File Number: 2016/401830
Our Ref: R/2016/9/A

State Significant Development 7542 – RPA Hospital Multi-storey Staff Car Park

I refer to your correspondence dated 14 June 2016 inviting Council to make a submission regarding the State Significant Development Application SSD 7542 for a multi-storey staff car park at Royal Prince Alfred Hospital at 67-81 Missenden Road, Camperdown (otherwise known as 106-112 Church Street).

**NORTHERN FACADE CLIMBERS DETAIL PLAN**  
SCALE 1:50 @ A3

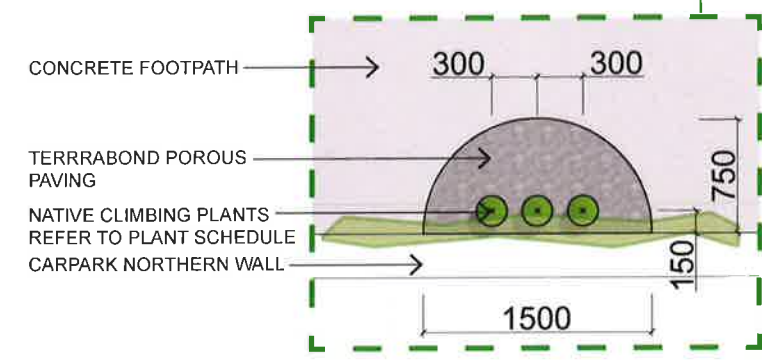
The landscape plan indicates a design intent to plant climbers along the facade of the building. This requires changing portions of the public footway to terrabond to allow water penetration to the root area. Due to the increased foot traffic at street level it is likely that the terrabond would result in increased maintenance needs. For this reason and the increased trip hazard risk to the public the design cannot be supported. It is noted that owner's consent from the City, as owner of the Lucas Street footpath, has not been obtained.

It is recommend that the applicant amend the plans to either delete the planting, or alter the building facade to accommodate the proposed planting wholly within the property boundary.

1 LUCAS ST FACADE SECTION A
1:40

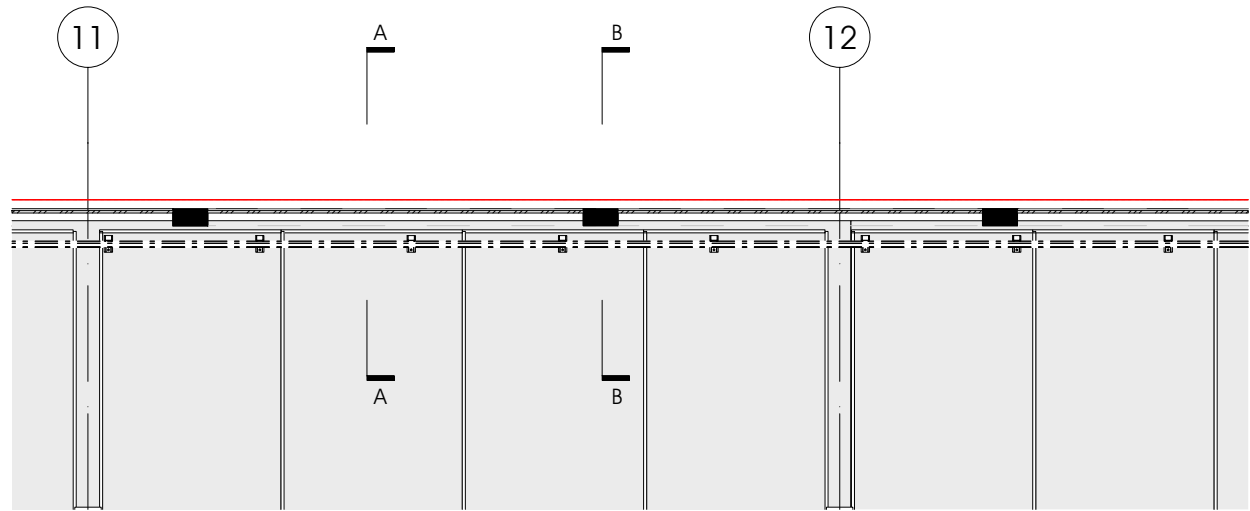
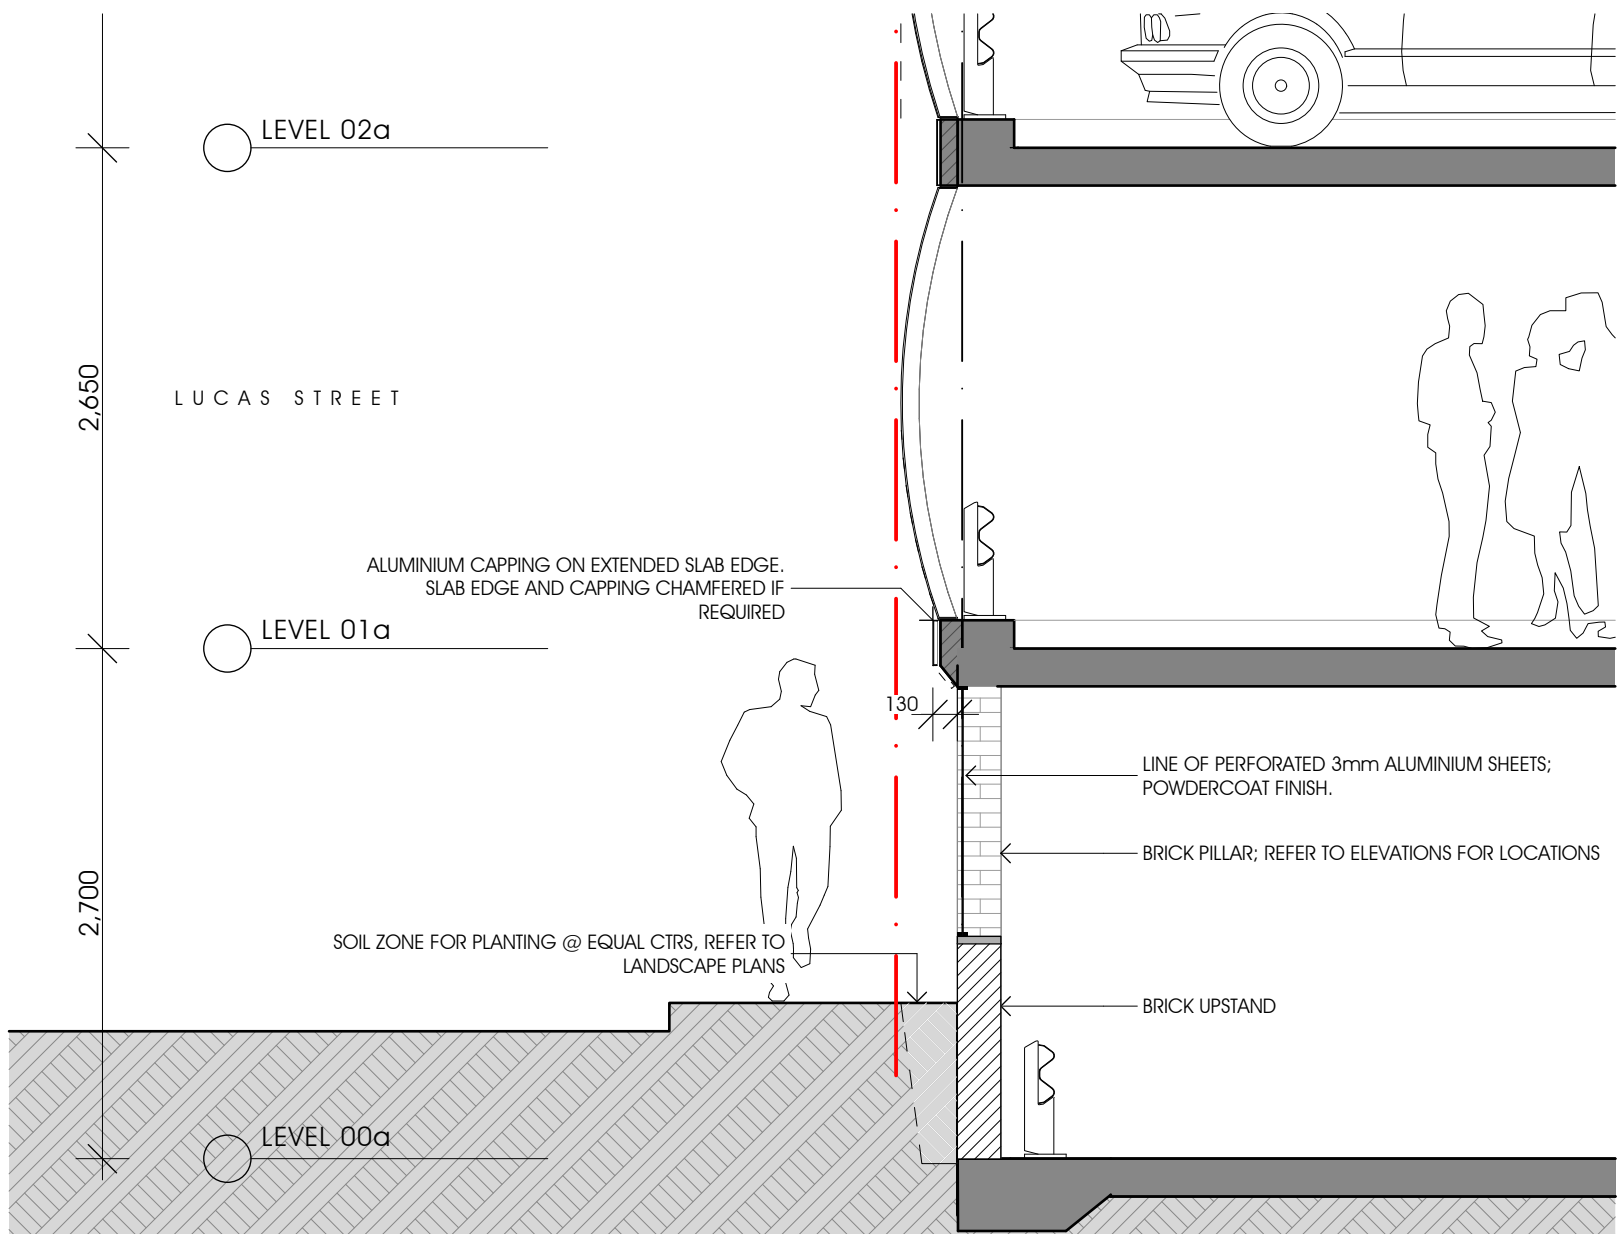
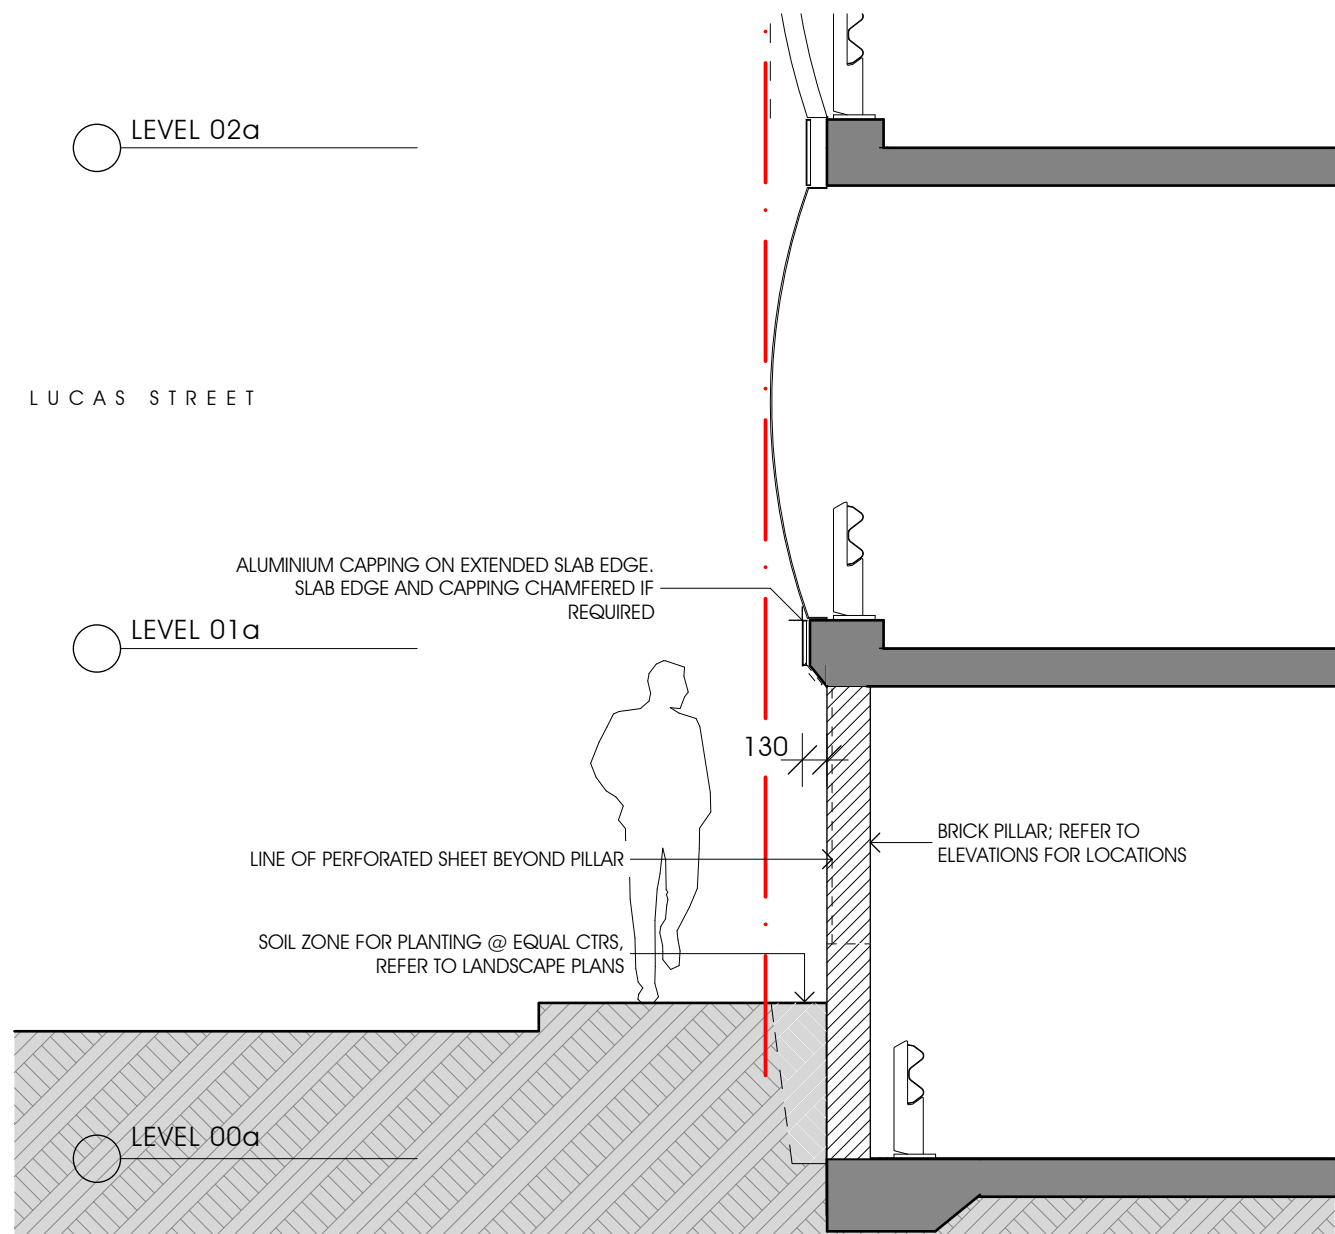
The facade design includes curved metal screens which overhang the building footprint at ground level. This is acceptable, however the Lucas Street Section on drawing DA-0206 shows that the overhang starts at a height of 1.65m over the footpath level at the point of the section. This is not acceptable, and a re-design is required to ensure that the building alignment is clear of obstructions for at least 2.5-3m above the level of the footpath.

BRODIE STREET ELEVATION

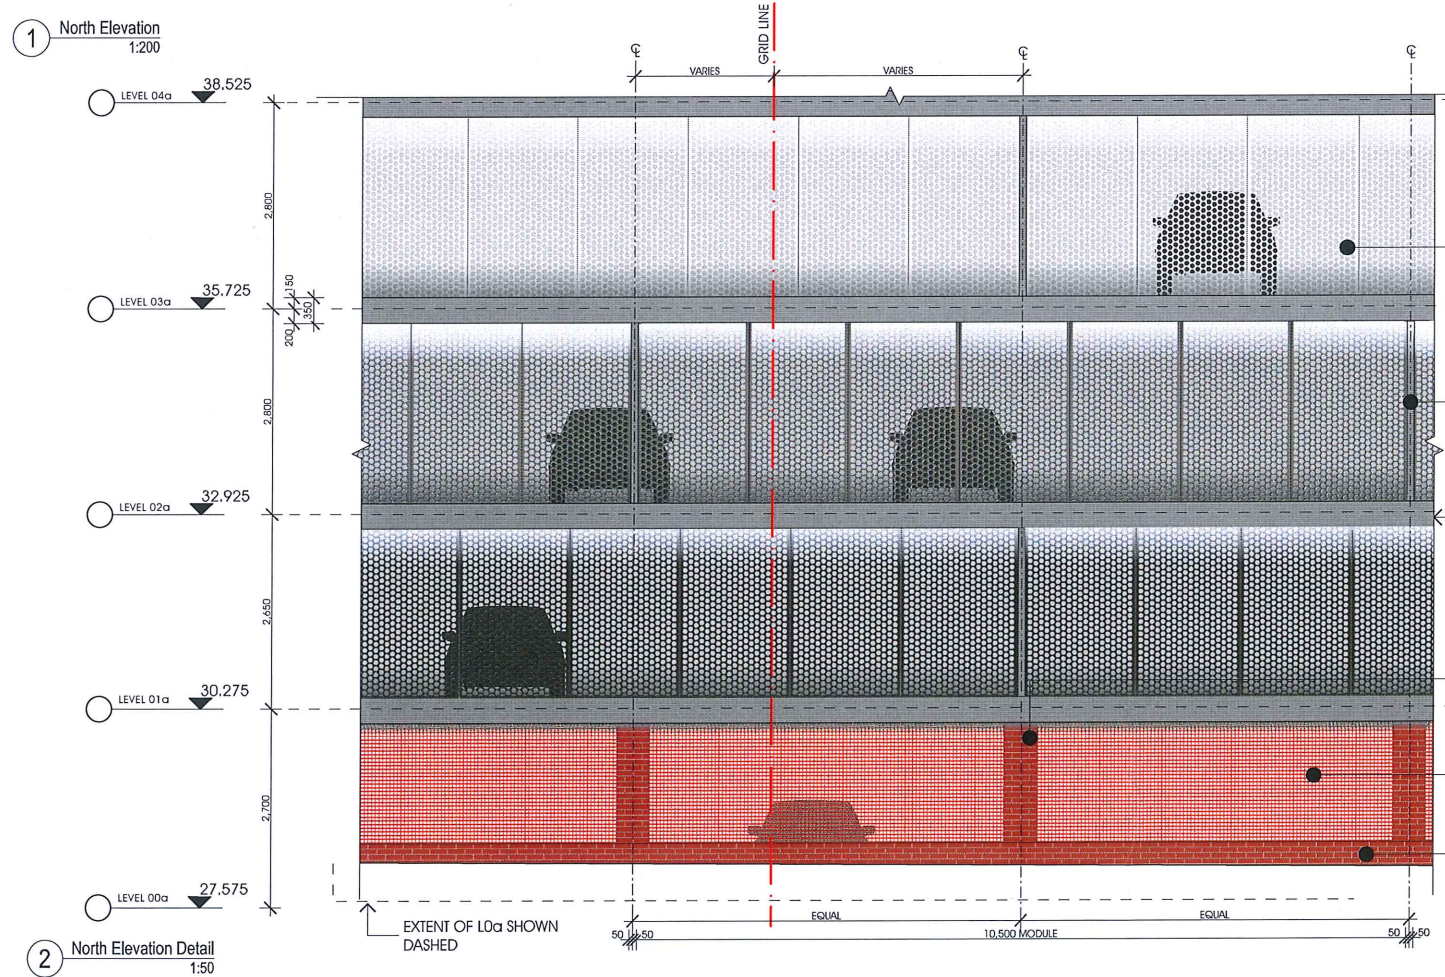
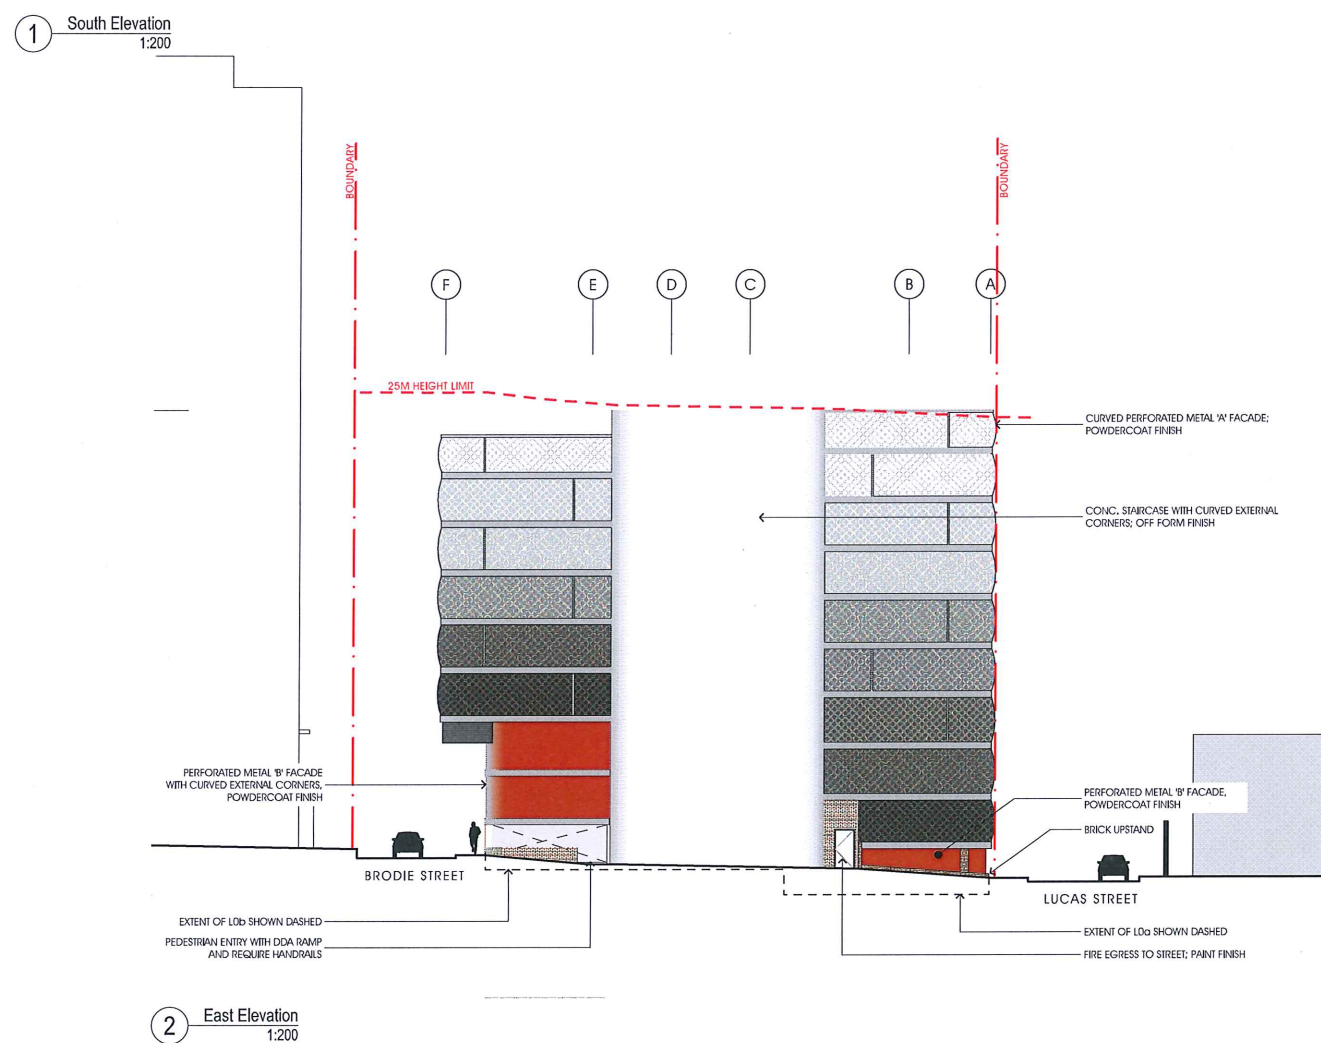
The potential for negative impacts of light spill is not properly addressed in the application. The detail elevation on drawing DA-0204 shows that the perforations may be in the order of 75-100mm in size, despite being labelled as 'small'. This will allow the building to 'glow' at night time, as the scale of perforations does not provide any barrier to light spill.

Currently proposed mitigation measures are limited to the top and bottom of the car park ramps on typical floors. This does not mitigate impacts to the remainder of the facades.

It is recommended that additional mitigation measures be considered to ensure that light spill does not negatively impact the surrounding locality. Measures should also be implemented to prevent headlight beams shining directly into habitable rooms in the Queen Mary Building (QMB).
